Comments for Planning Application 20/04376/FULL1

Address: 59A Chislehurst Road Chislehurst BR7 5NP

Proposal: Subdivision of existing 3-bedroom maisonette into 2x 2-bedroom flats with associated parking, refuse storage, cycle storage and erection of glazed roof terrace (to Nos. 59 and 59A Chislehurst Road).

PROPOSED ELEVATIONS
 Scale: 1/100

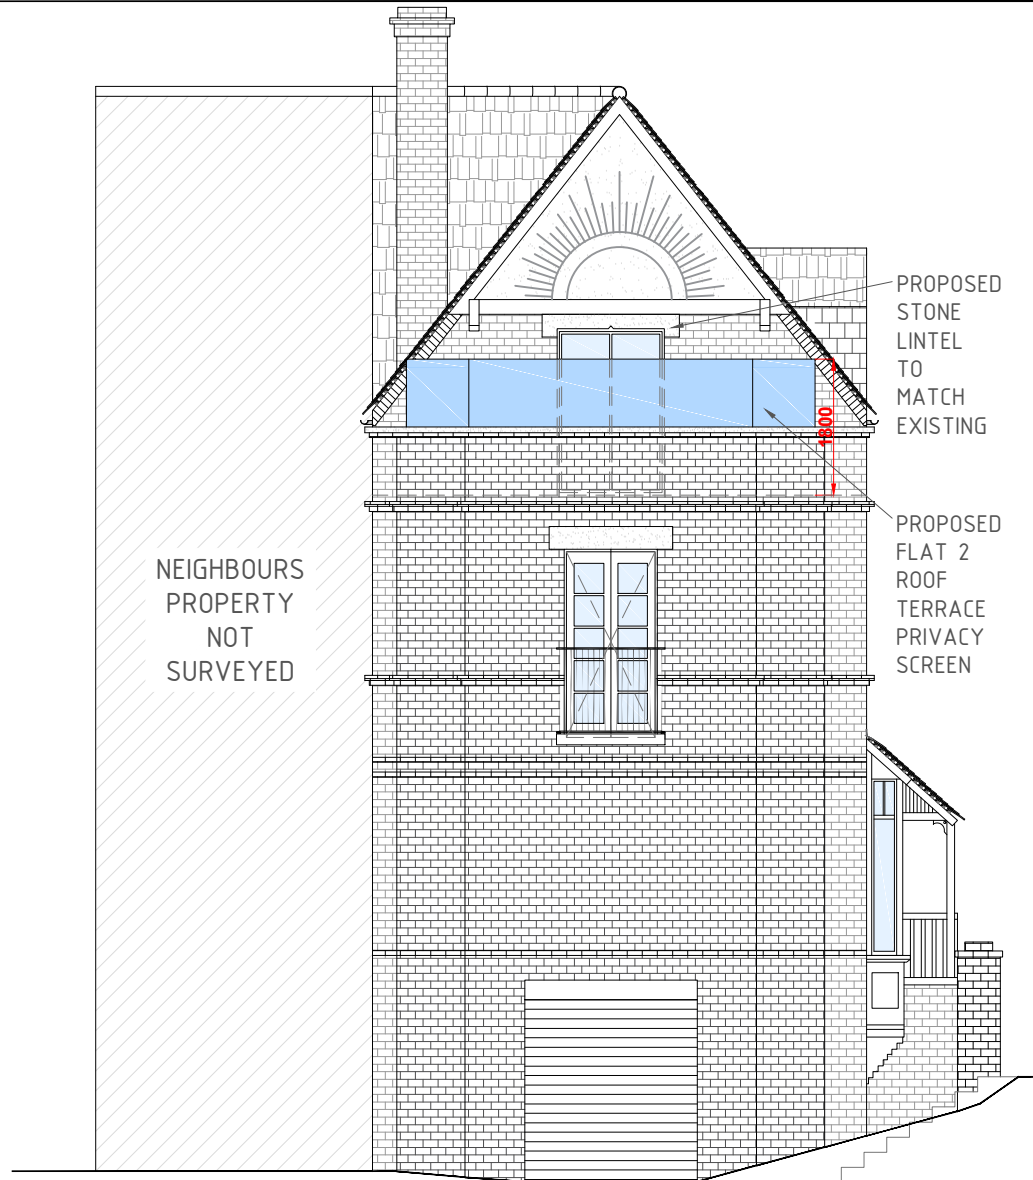
- Looking at the proposed elevation, Flat 1: there's a new opening window proposed a part of the new erected bedroom looking over Lower Camden street, this is a clear violation to our privacy living at the opposite side at 1st floor flat Ardmere house. we already suffer a lack of privacy due to the number of existing tall sash windows, often we are forced to keep our curtains closed most of times compromising on natural light in order to protect our privacy. the new subdivision will attract to double up the number of individuals would live within same living space and this will violate residents privacy on both sides more over this will kill our chances to use our small balcony.
